**Environment, Planning and
Enforcement**

15 February 2019

**Re: Application by RiverOak Strategic Partners for an Order Granting
Development Consent for the upgrade and reopening of Manston Airport
– Written Representation Submission**

Title ACCESS AND RIGHTS OF WAY PLANS
 REGULATION 5 (2)(k)
 THANET DISTRICT COUNCIL
 SHEET 4 OF 5

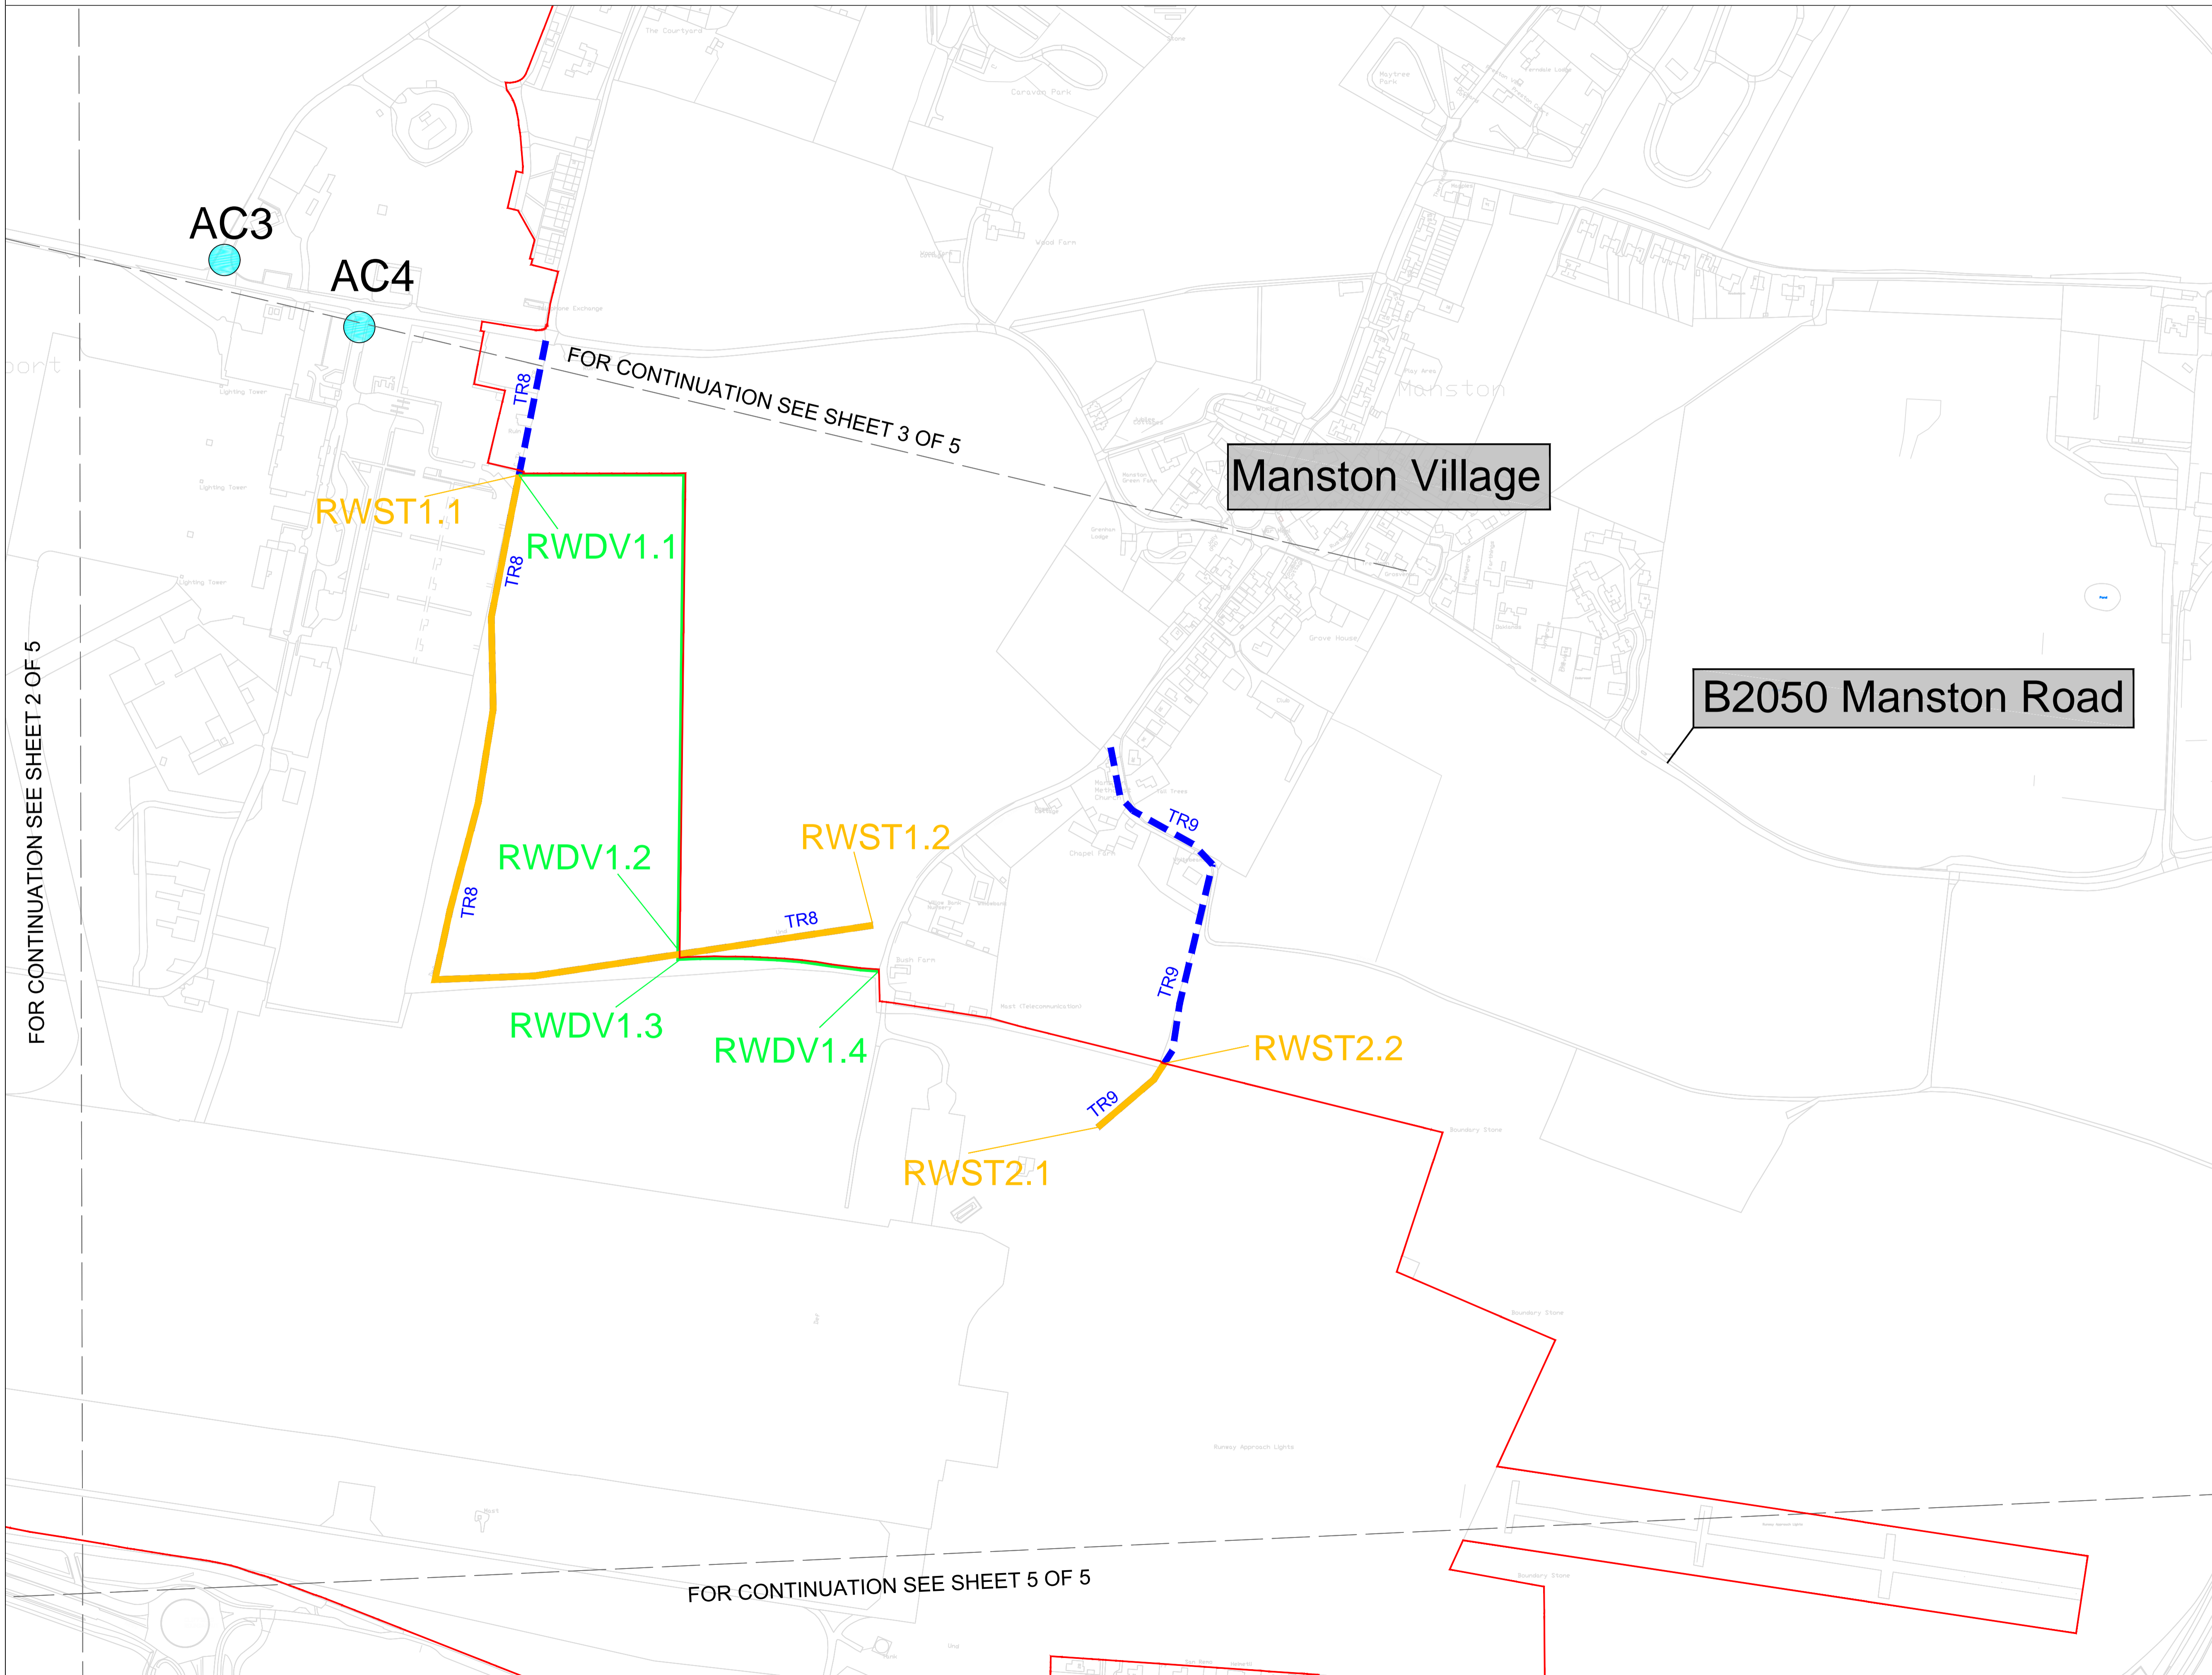
It is understood that the PRoW TR8 will be rerouted along the edge of the new proposed perimeter fence of the airport, with the previous route permanently closed and a new route permanently established. It is requested that contact is made with the KCC PRoW and Access Service at the applicant's earliest convenience, to discuss any required route diversions. In respect of ongoing maintenance, it will be expected that the site operators will take on ongoing maintenance responsibilities for any landscaping and enhancements along the bridleway and PRoW network.

The County Council would expect monies to be secured to improve the surface of the existing and diverted bridleways to a minimum width of 3m along the entire length, which will include bridleways TR8 and TR10.
